From: 43 Northaw Road East, Cuffley

19th October 2016

To: Mr S Dicocco, Case Officer, Welhat Borough Council

Re: Decision by the Development Management Committee dated 18th August 2016 - All Side Facing Dormer Windows of No. 45 shall be fixed and glazed with obscured glass.

North Facing Elevation windows

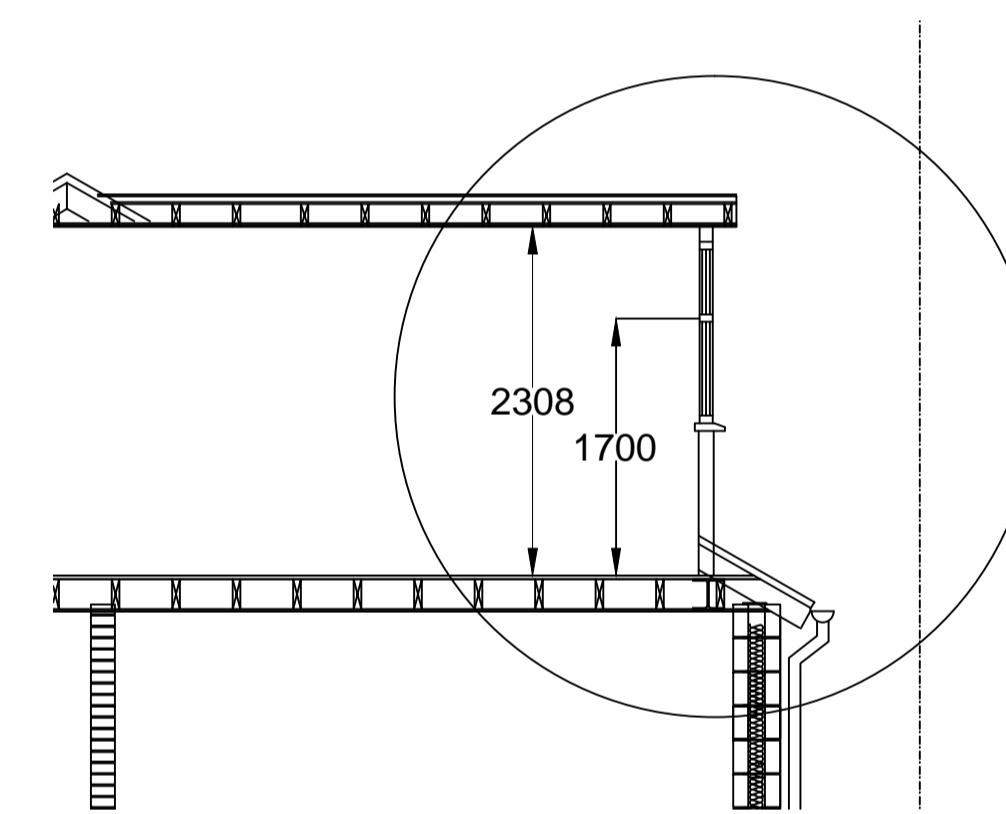
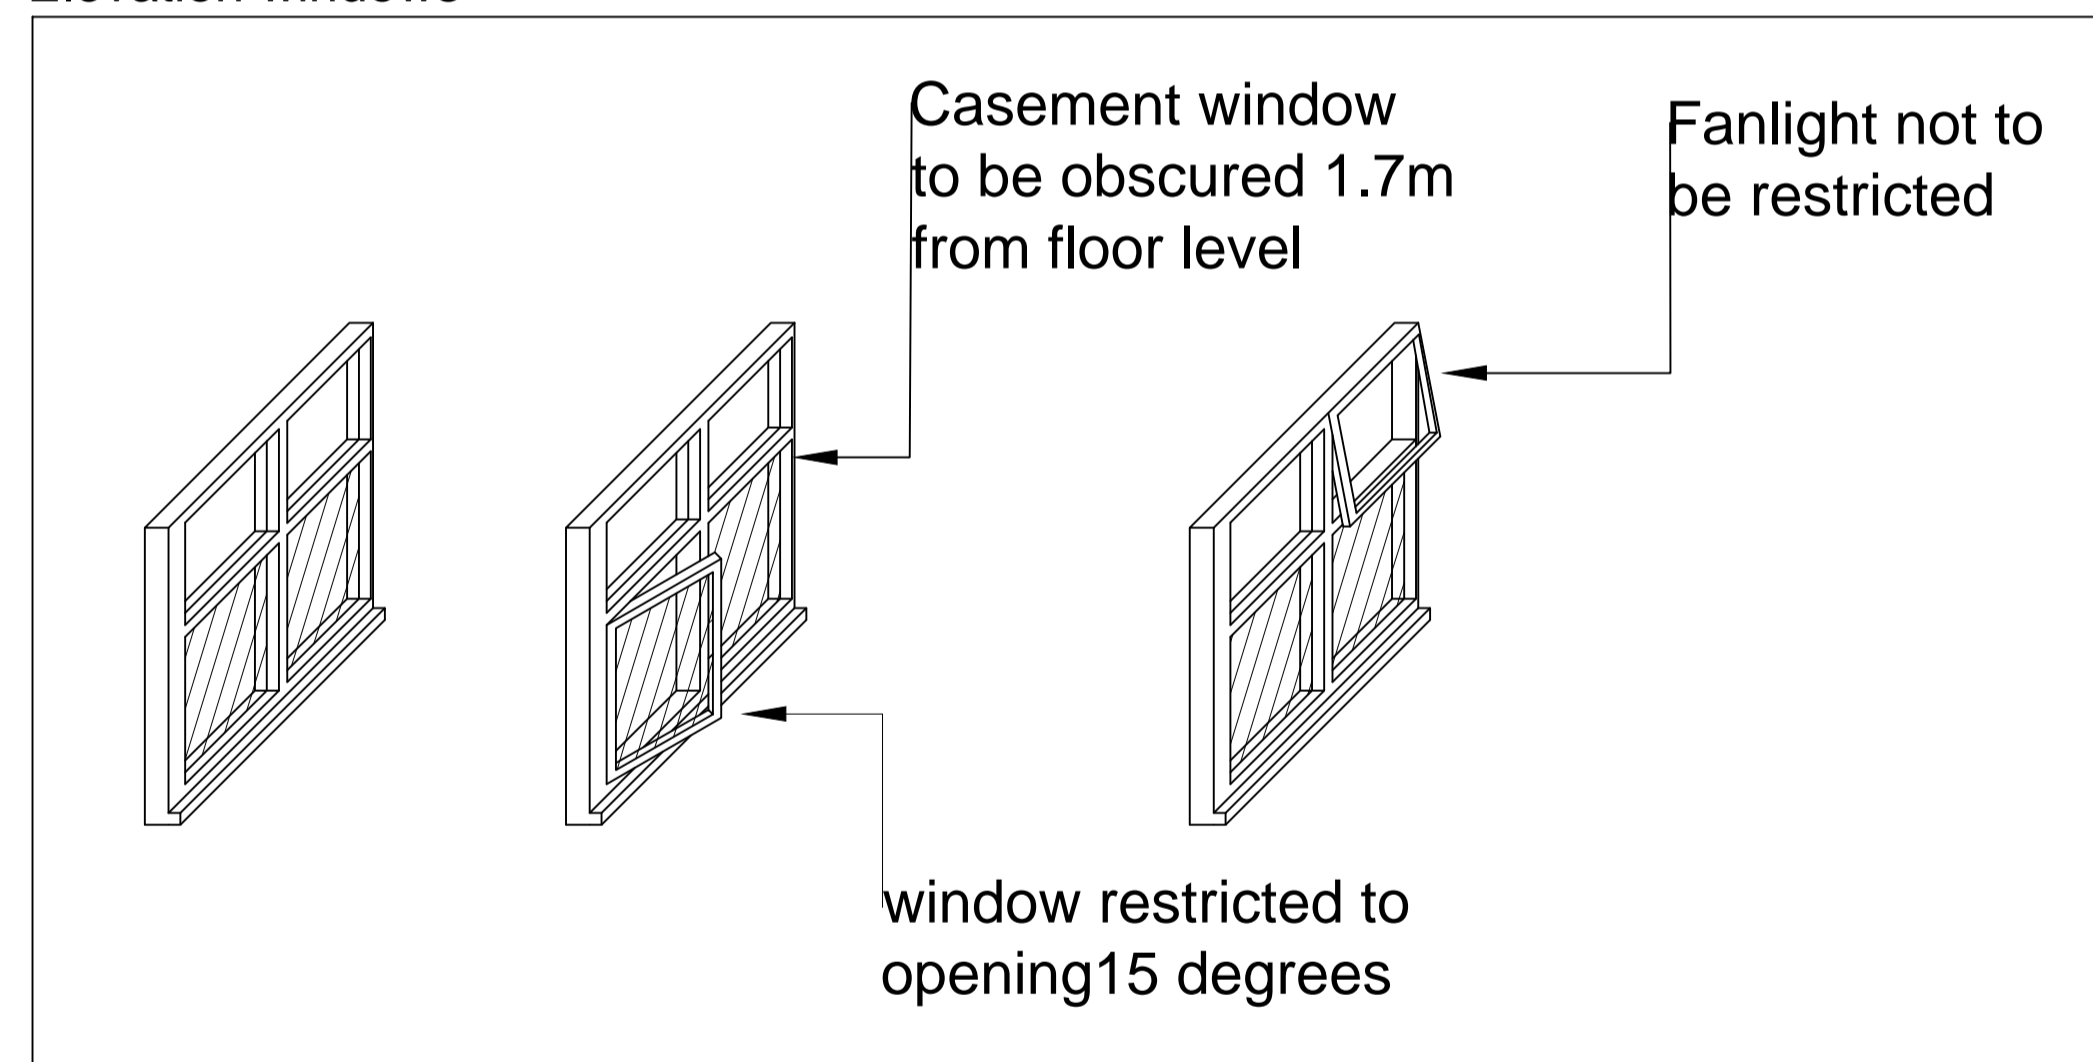
As stated during the meeting and supported by photographs taken from within our house (attached for reference), the Middle Dormer of No. 45 (which has an additional unauthorised Window) looks directly into our bedroom skylight which is the sole source of light (i.e. only window) in the bedroom, is of clear glass and has no window dressing. Our grand-children frequently use this bedroom. We find it shocking that anyone should have the ability to a full view of ourselves and that of our grand-children sleeping and either getting dressed or undressing in this bedroom. The Kitchen Skylight is also over looked by both of No. 45s middle and rear Dormer Windows. Our kitchen is in constant use as my wife is at home and therefore uses it throughout the day.

- a) We strongly object against the removal of the condition, as it would result in No. 45 having a direct view of ourselves and our grandchildren - a clear breach of our Human Right to Privacy, a scenario which we do not believe to be reasonable or fair. Furthermore, we believe that consideration must be given to the fact that the dormer windows of No. 45 are not a transitory matter and that this decision does not only affect us and the owners of No. 45, at this point in time, but will also affect all future occupants and owners of No. 43 and No.45, of which no speculation can be made over whether future occupants of No. 45 choose to look into our bedroom and invade our privacy or not.
